From: Martyn White
Sent: 16 October 2013 14:43
To: Planning.Responses
Cc: Janice Chapman
Subject: RE: Planning Consultation on: Y/54/13/L

**ADC Planning Consultation
Response from the Conservation Officer**

Application Number	Y/54/13/L
Address	Bonhams Farmhouse, Yapton
Description	Application for Listed Building Consent for removal of 5 no existing rotten sash windows and replacement with 5 no new purpose made box sash windows on front elevation (W1-W5). Refurbishment of 4 no windows on single storey addition (W6-W9).
Case Officer	Janice Chapman

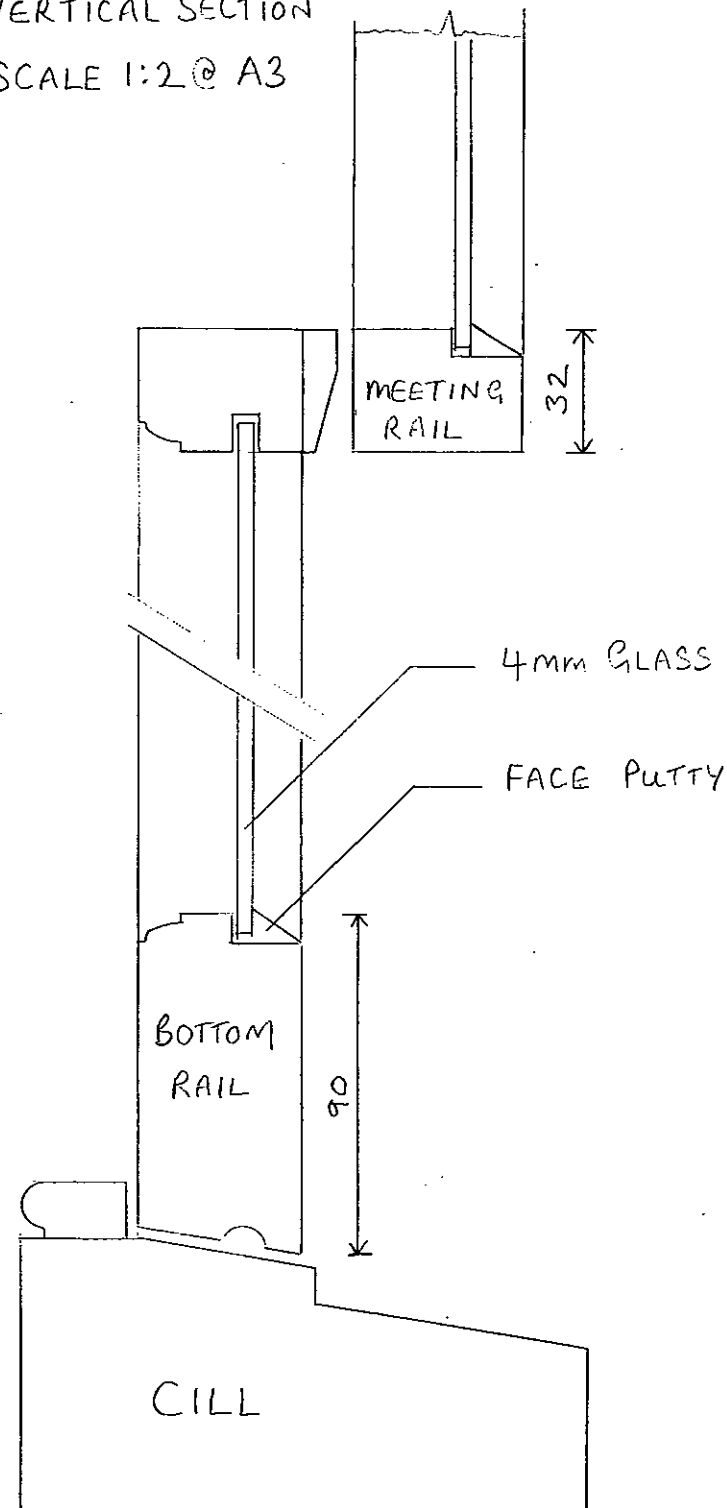
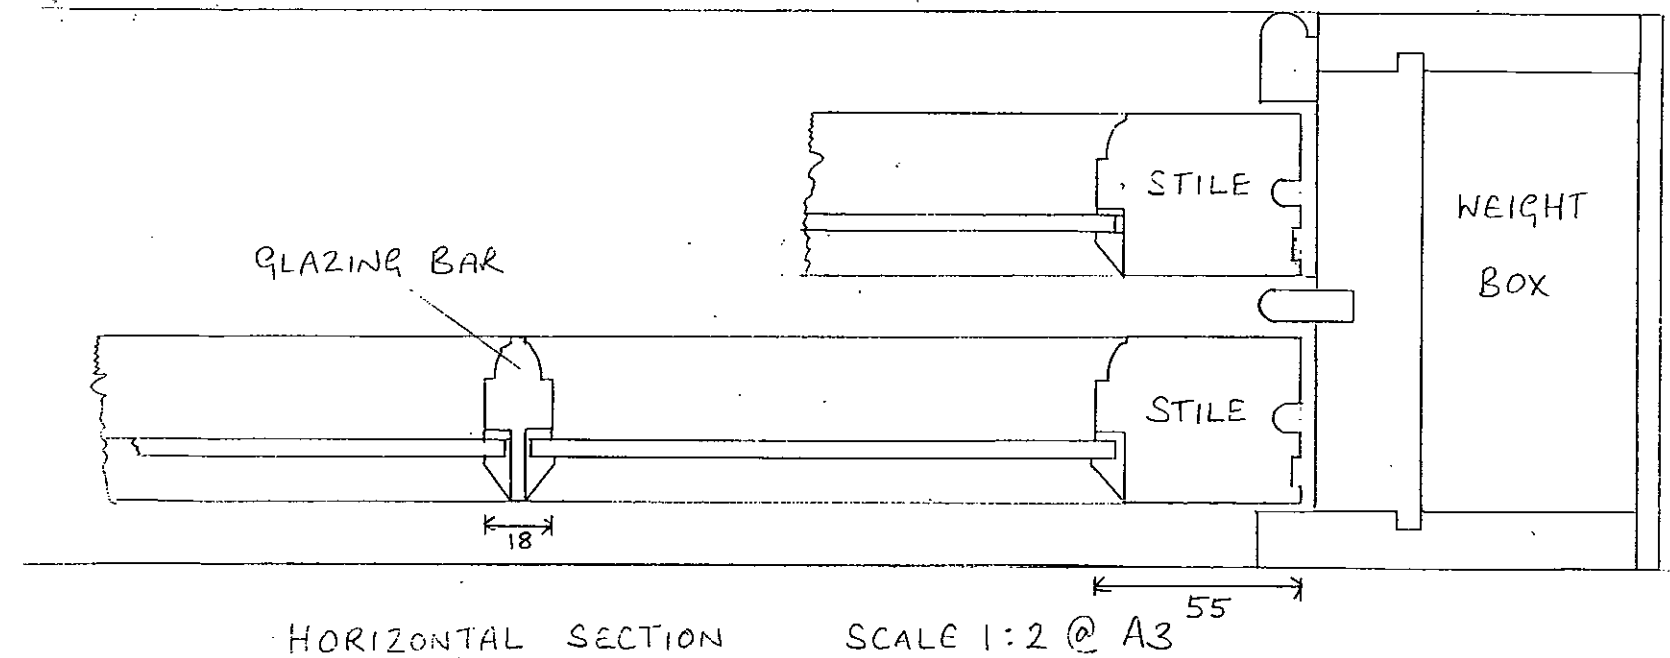
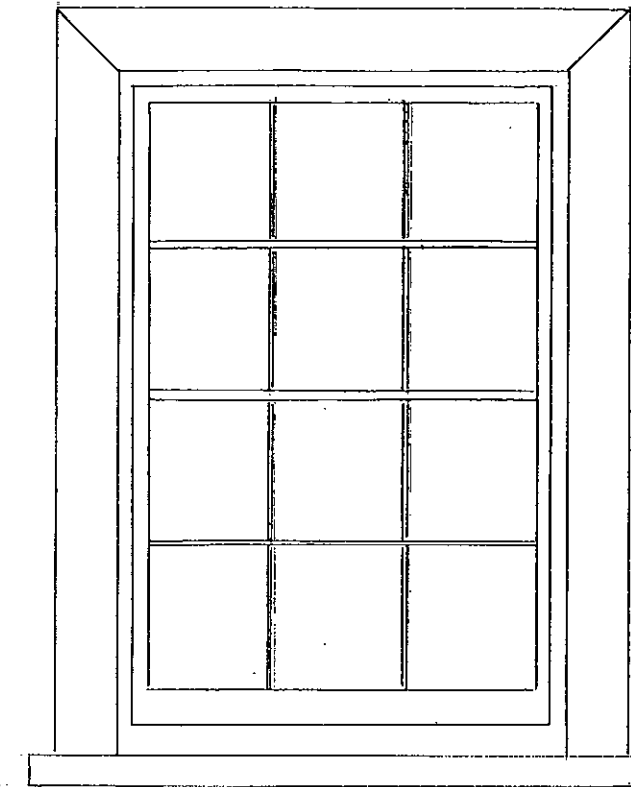
However, I am of the opinion that the existing glazing should be retained and re-used if it is found to be crown glass.

Retention of any crown glass
